Planning reference: 3/2025/0147

Location : Peel Street Business Estate, Peel Street, Clitheroe, BB7 1RA

Proposal : Proposed demolition of existing buildings and erection of six 2-bed and one 3- bed apartment building together with a two storey business centre and associated parking and bin store

We refer to the letter from the Environment Agency dated 17th April 2025 in which the Environment Agency objected to the above planning application. The Environment Agency's reasons for objection are as follows, along with our responses.

PROPOSED RESIDENTIAL BUILDING

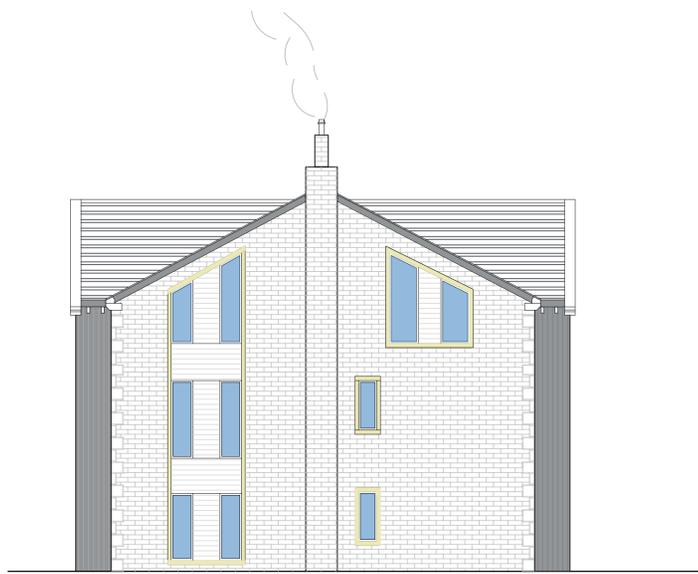
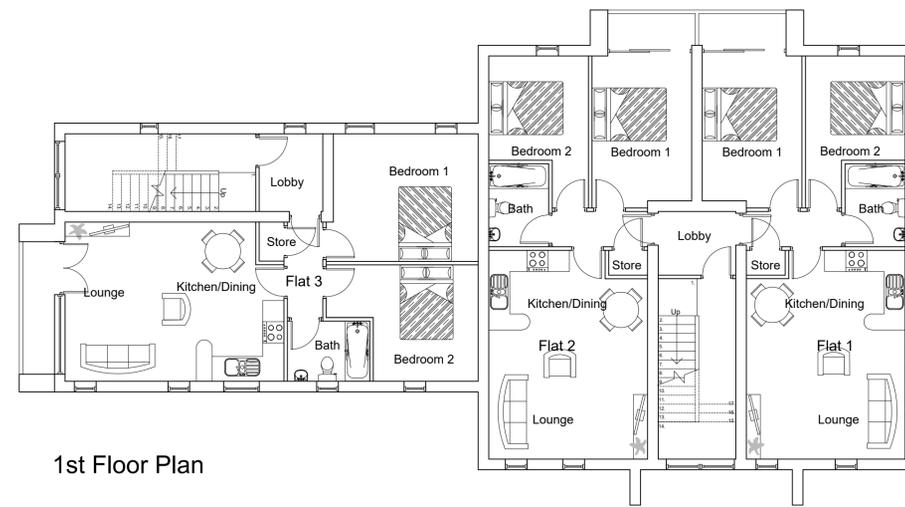
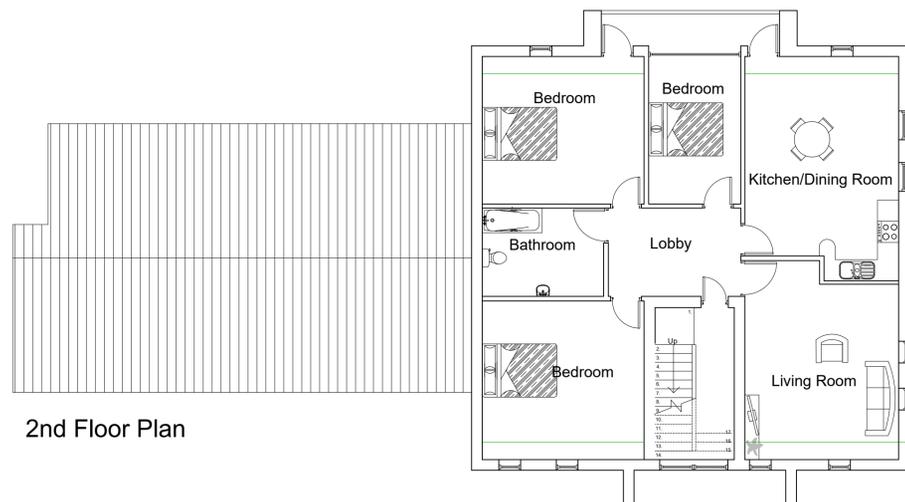
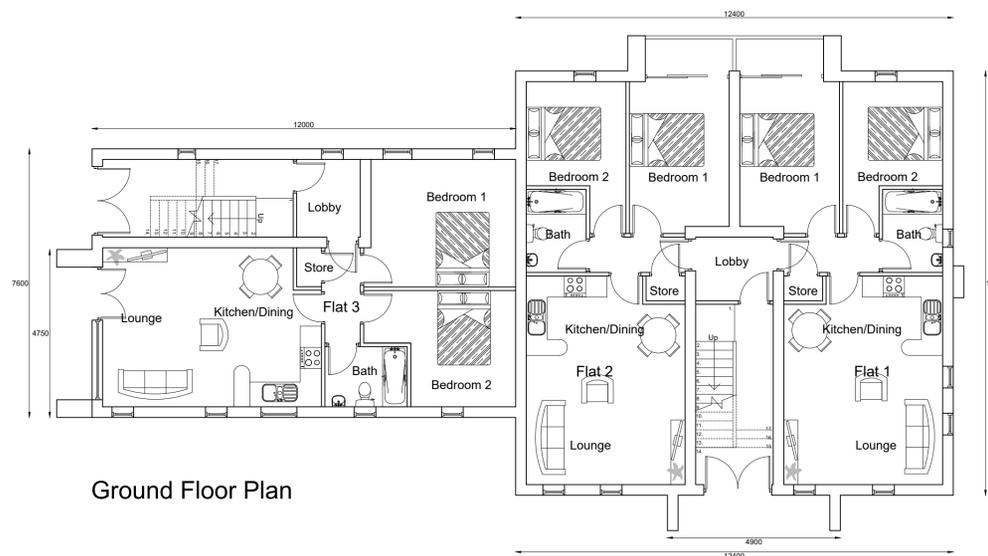
3. The FRA states: "Only the office building that is to lie within the south of the site lies within the area of the site where the ground levels are below 74.64m AOD. The residential building planned for the northern part of the site lies above 74.64m AOD and will not be affected by the 1% plus 35% event."

The Environment Agency's Mearley Brook 2018 hydraulic model shows that the flood outline for the defended 1% Annual Exceedance Probability event (plus 35% climate change) does affect the northern residential "Building 1" – at least at its western / southern reaches. This implies that current ground levels at the land surrounding the

northern building may be lower than 74.64m AOD - given that the incorrect peak river flow climate change allowance has been relied upon, design flood levels may be higher than this level.

From the topographical survey it can be seen that the existing ground levels where the residential building for the northern part of the site is planned lies above 74.64m AOD. However, it is accepted that existing ground levels within the vicinity of the south western corner of the proposed building may be below 74.64m AOD.

We have stated earlier that the floor levels of the proposed buildings are to be set at a minimum 74.95m AOD, which will be 300mm above the design flood level of the 1% plus 36% event.

It is noted that an application for an Environmental Permit will need to be made to the Environment Agency as the proposed building within the northern part of the site will lie within 8m of the Mearley Brook, which is designated Main River.
